Engineers Comments Regarding Surface Water Drainage

Application Reference:	Y/19/25/DOC	Reviewer Reference:	ADC/EXT4
Planning Officer:	Simon Davis	Date of Review:	15.09.25
Site Name:	Land North of Yapton C of E Primary School North End Road Yapton		
Application Description:	Approval of details reserved by condition imposed under reference Y/88/18/OUT relating to condition number 17 - surface water drainage system.		
Assessment Number:	2 of 2

ADC Drainage Comments	ADC Response	Designer Response	ADC Response	
Date	[Y/2/24/DOC] Dates as shown	16/06/2025	01/07/2025	15.09.2025	
Condition Number: 17

Time Area Diagram for Dam 12 (ch.100) to chainage 210 at outfall E (pipe E1.001)

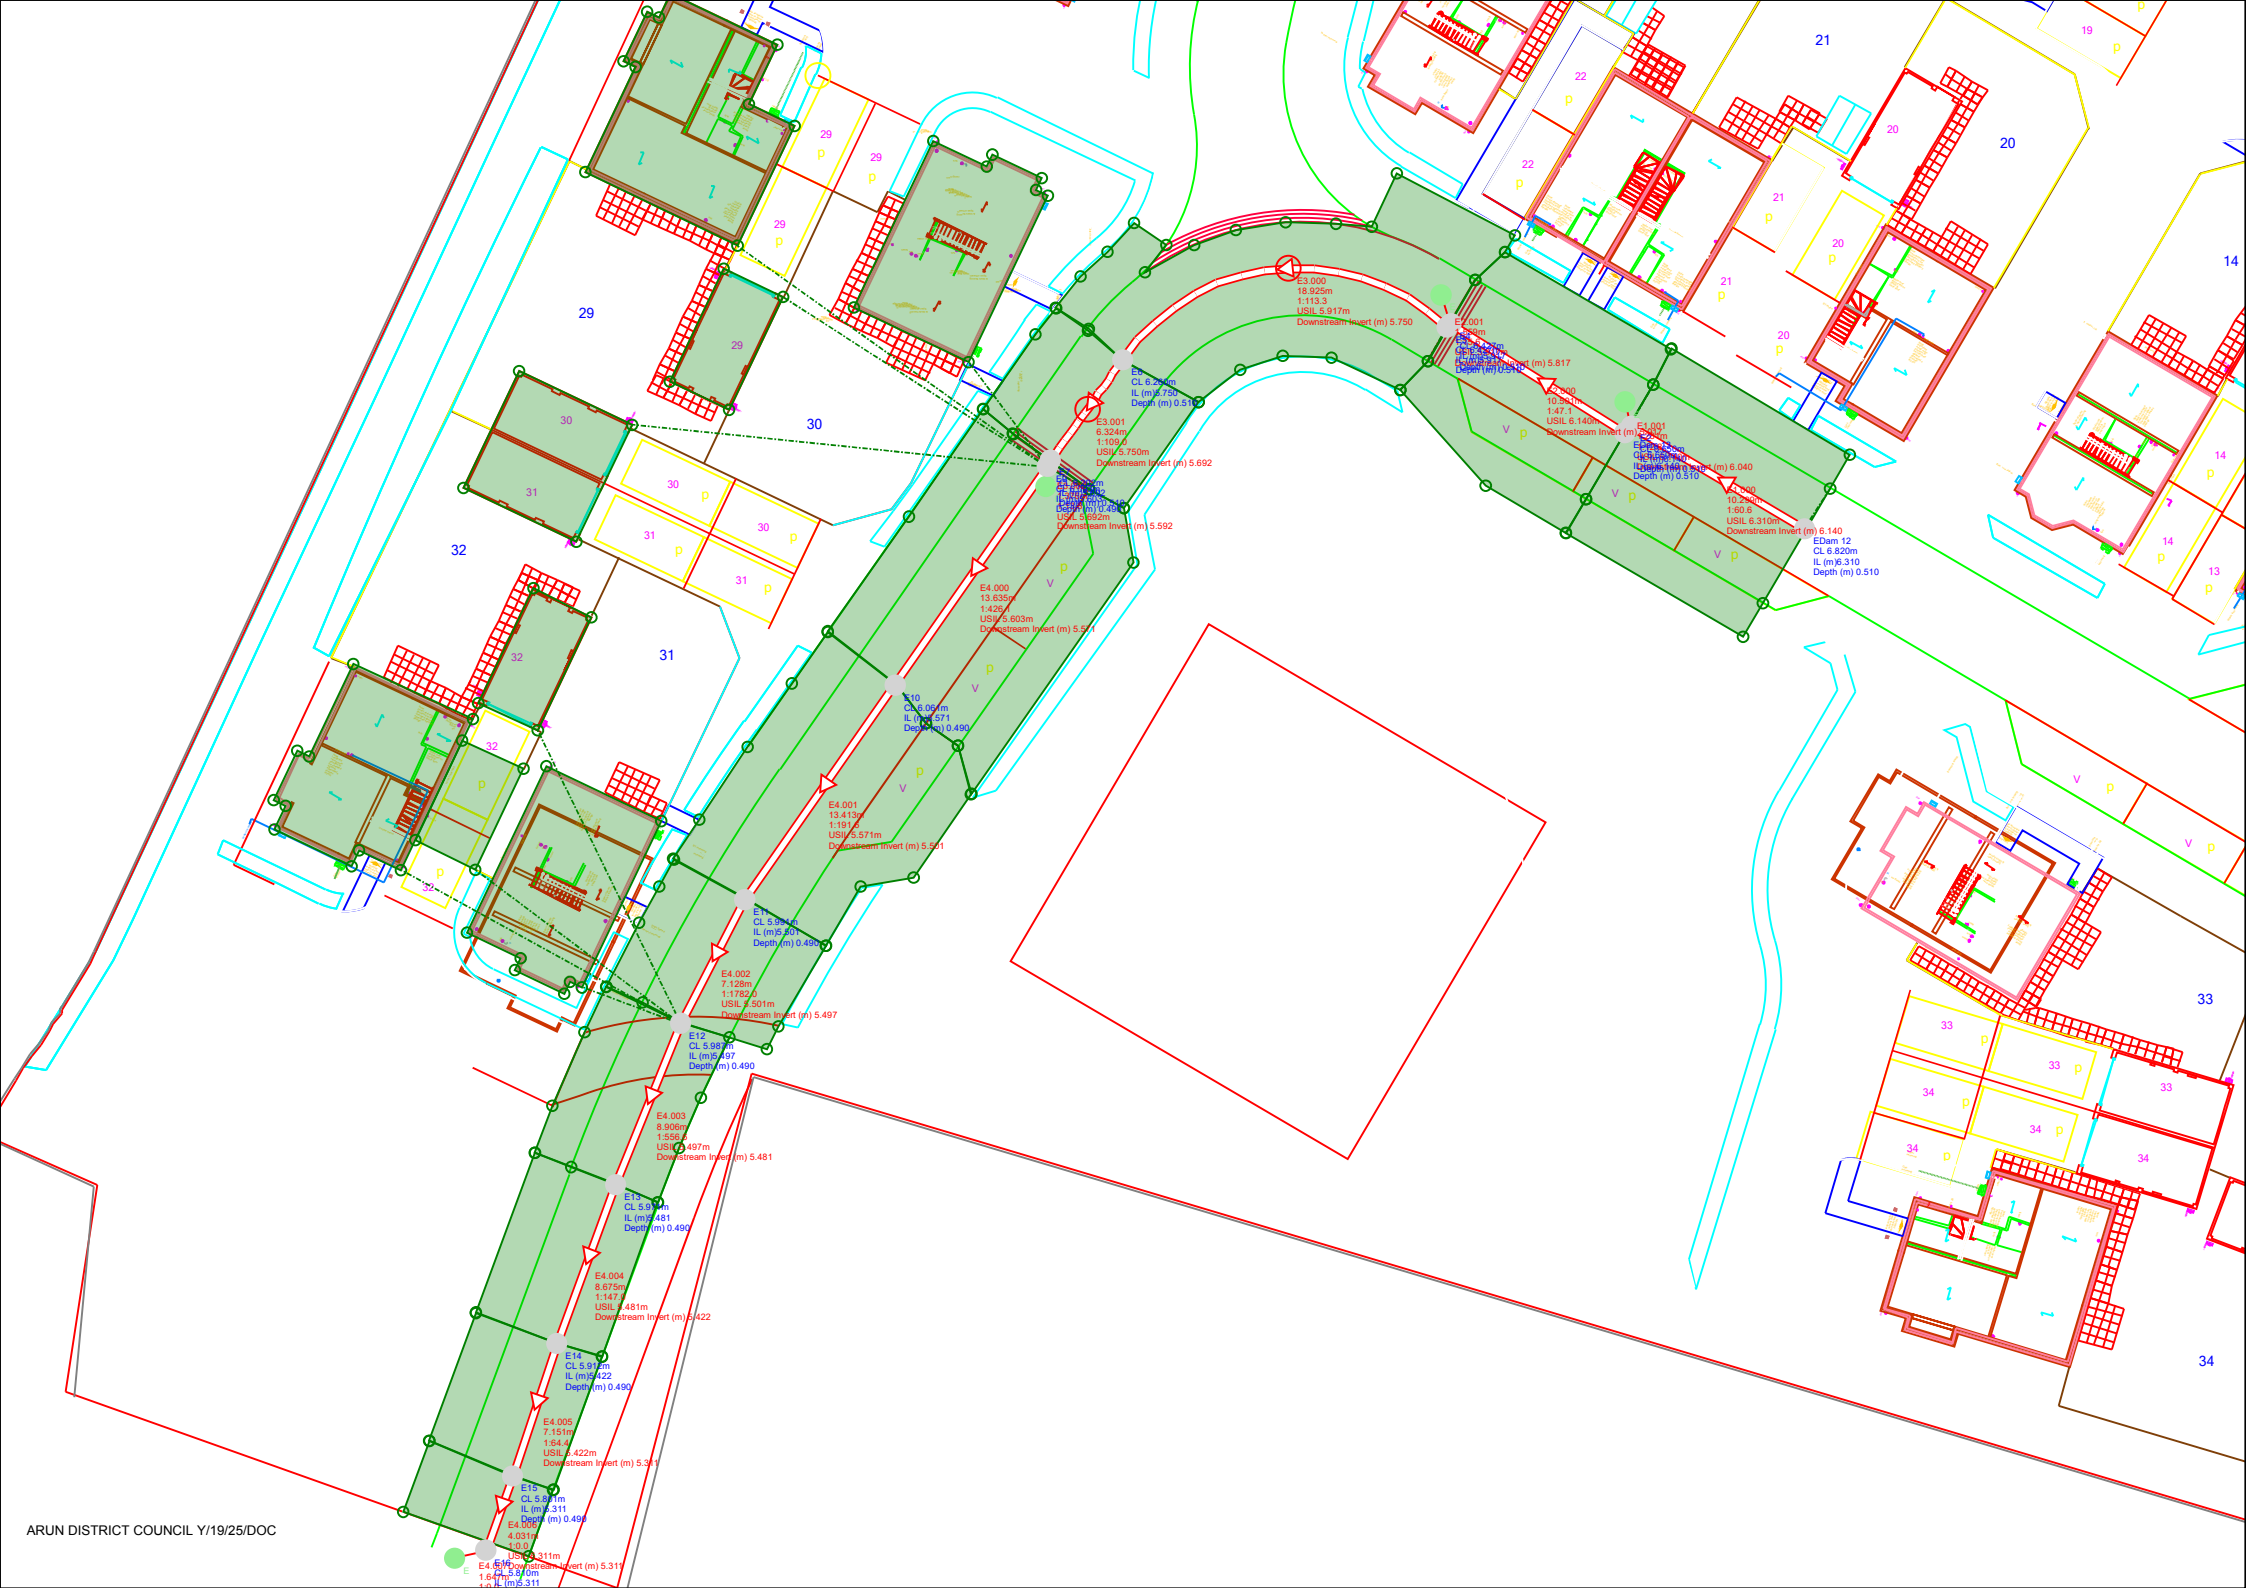
1.	ADC Drainage Comments (20/03/2024): Please provide the updated drainage calculations following receipt of the as-built survey. Also confirm that the very small flooding amount mentioned on paragraph 3.1.1 is routed within the site as previously agreed in the approved drawings. Designer Response (02/05/2024): The calculations based on the as-built survey were included in Appendix D of the Drainage Completion Report. ADC Response (27/06/2024): - CV value should be equal to 1. If a different value has been agreed, please provide the relevant evidence. - Please also provide half drain times for the 1 in 10y + CC and 1 in 100y + CC storms. - We understand that the flooding calculated is minimal however this amount might be higher with the CV equal to 1. Please provide a drawing explaining how the flooding will be tackled. If this has been previously agreed, please provide the relevant evidence.	Even though there is satisfactory explanation regarding the minimal amounts of flooding the calculations should be updated in accordance with the previous comment. Comment remains.	The CV value used is the default setting within Micro Drainage, which is industry standard software for drainage calculations. We used the same CV value in the initial approved design, so amending it for an as-built scheme would not be a reasonable request from the council.	Thank you its noted in relation to the CV value. Please note that whilst calculations have been provided for the permeable paving, the main surface water calculations associated with the large infiltration blanket/soakaway need to be provided. In addition to these these calculations will need to demonstrate the modelling for the as -built 150mm diameter pipes leading to this soakaway which differ from the design drawings which specify these as needing to be 225mm diameter.

AS-BUILT (38 UNITS)
PERVIOUS PAVEMENT SUB-GRADE

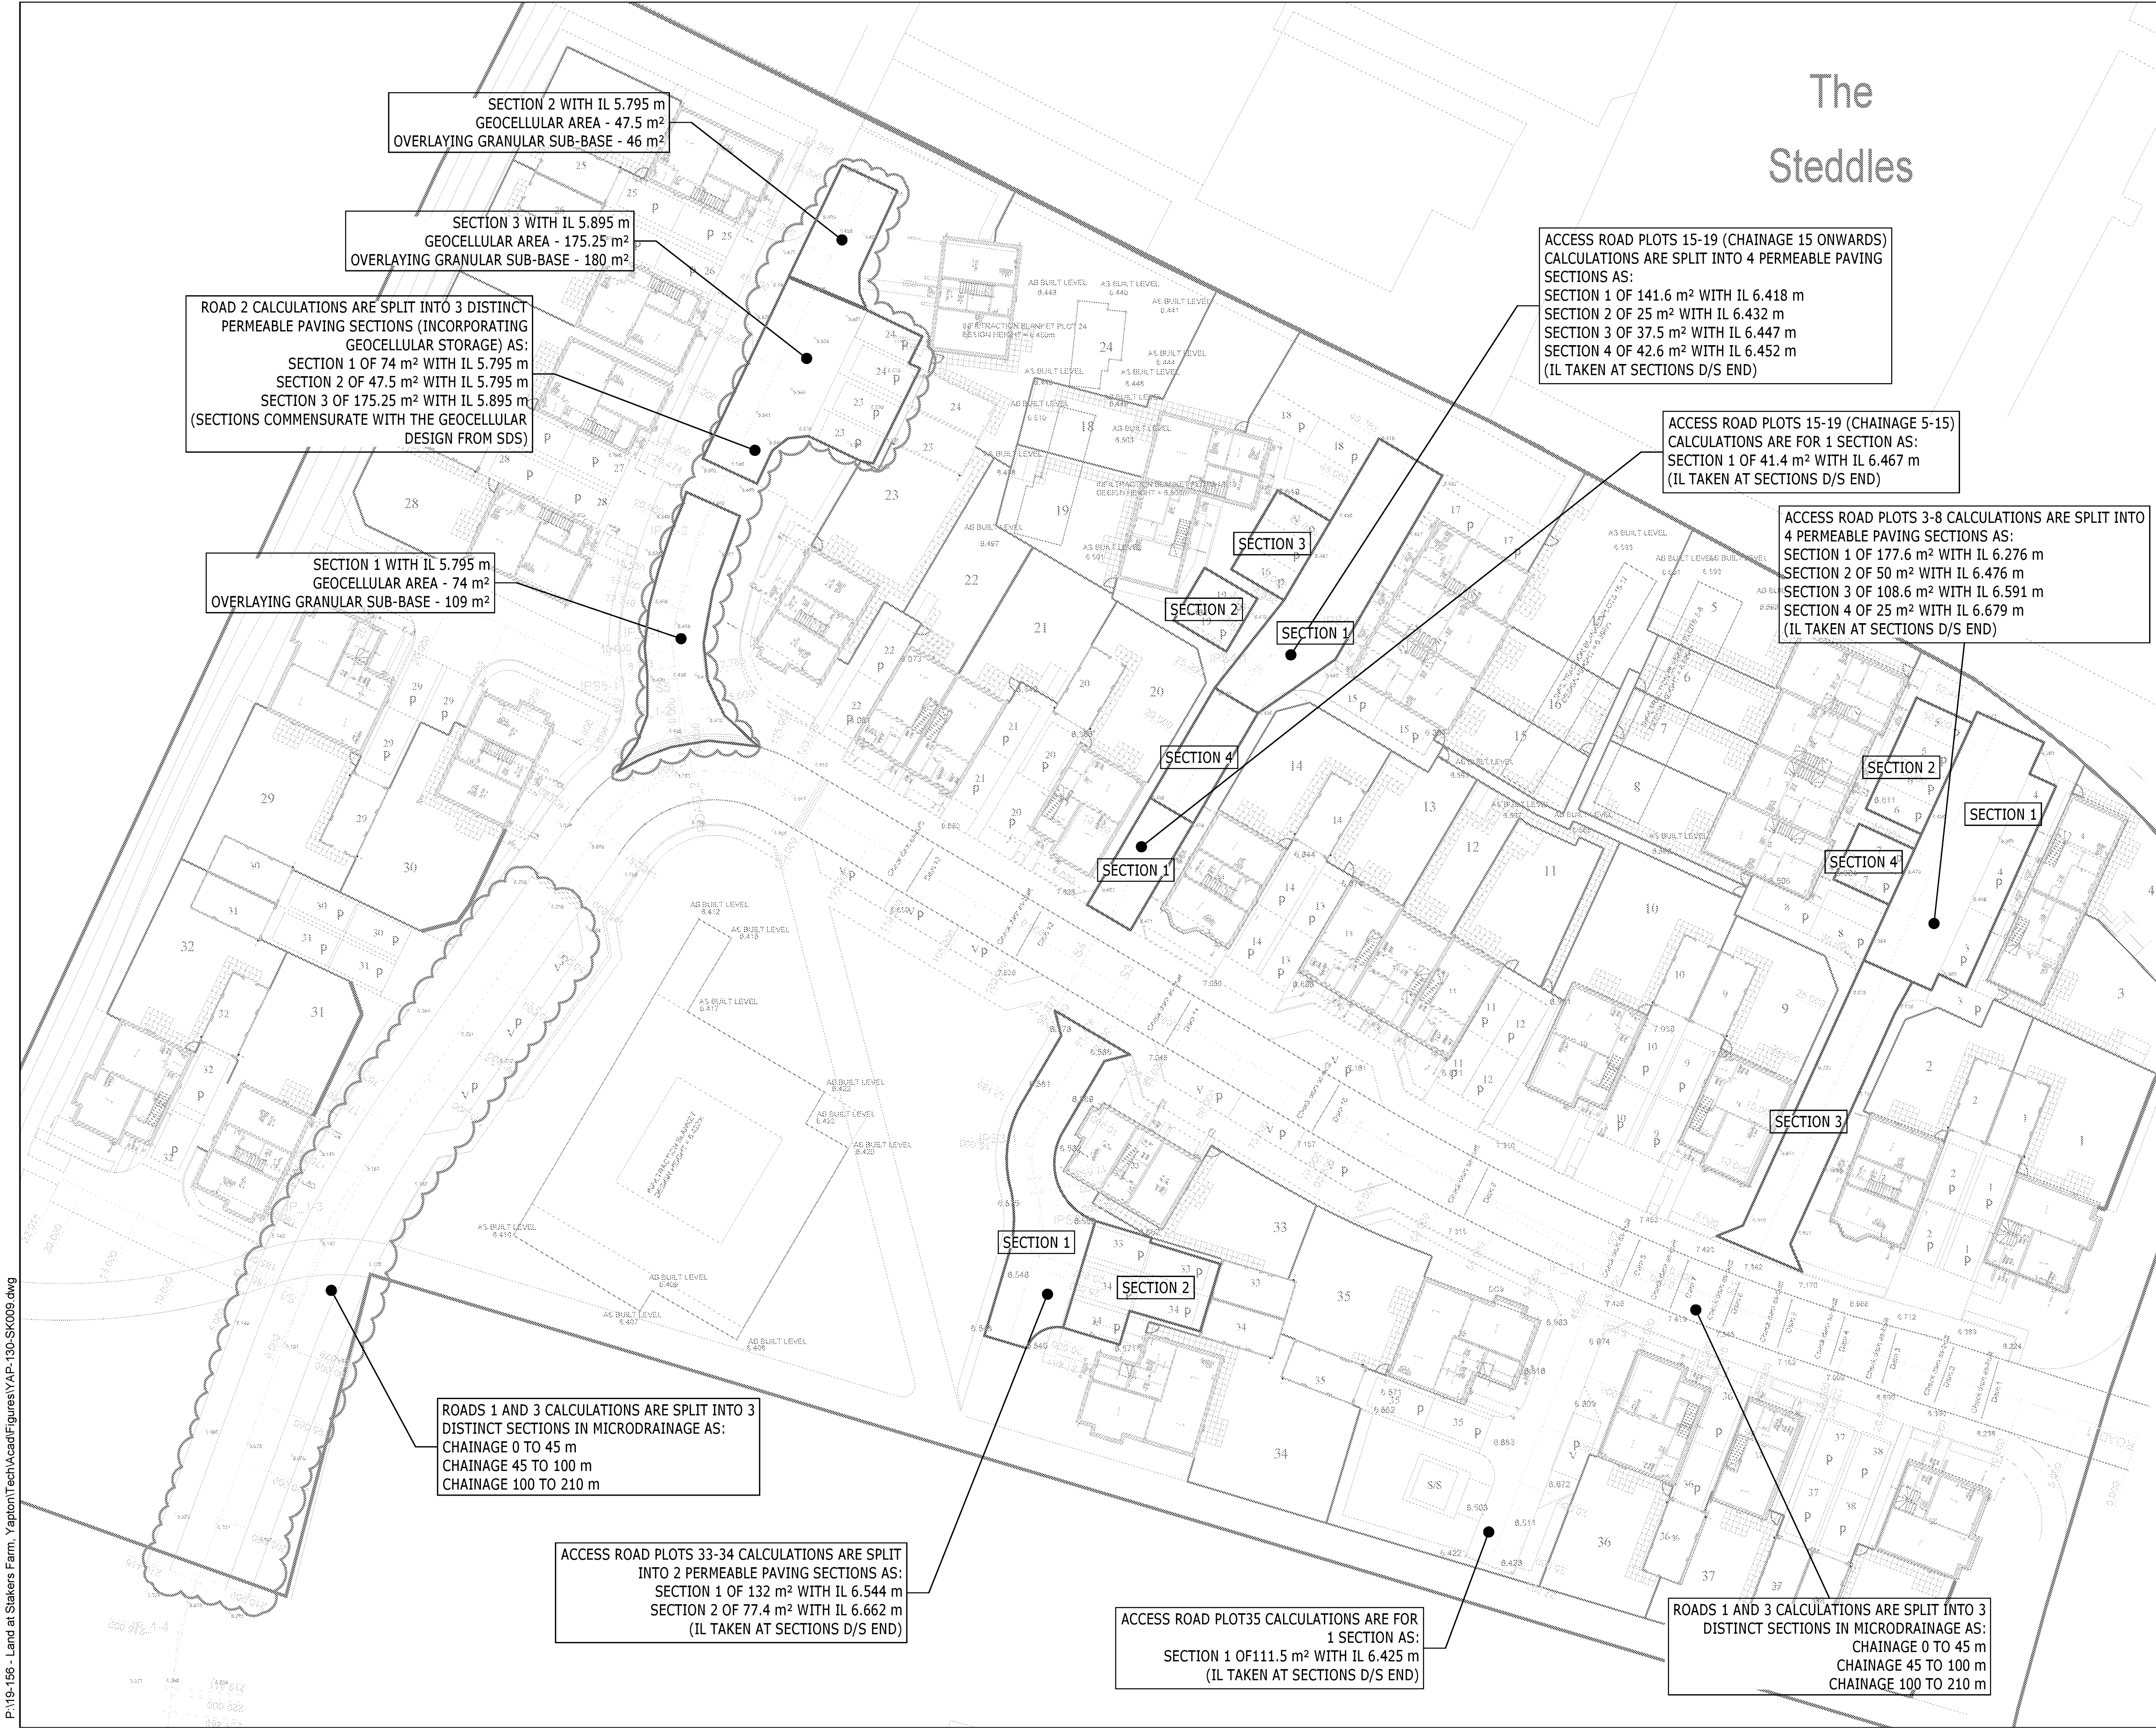
6.	ADC Drainage Comments (20/03/2024): On the as-built drawing please provide as-built details for all the infiltration blankets their base level, their height, cover level and plan dimensions. (Copy information from Appendix G) Designer Response (02/05/2024): This has been given already for the sections in open land, those within private owned land we cannot obtain which was accepted some time ago. ADC Response (27/06/2024): Agreed and closed

7.	ADC Response (27/06/2024): Please provide as-built information for all the drainage features including those around the private properties, eg manholes, pipes, infiltration blankets etc	Comment closed
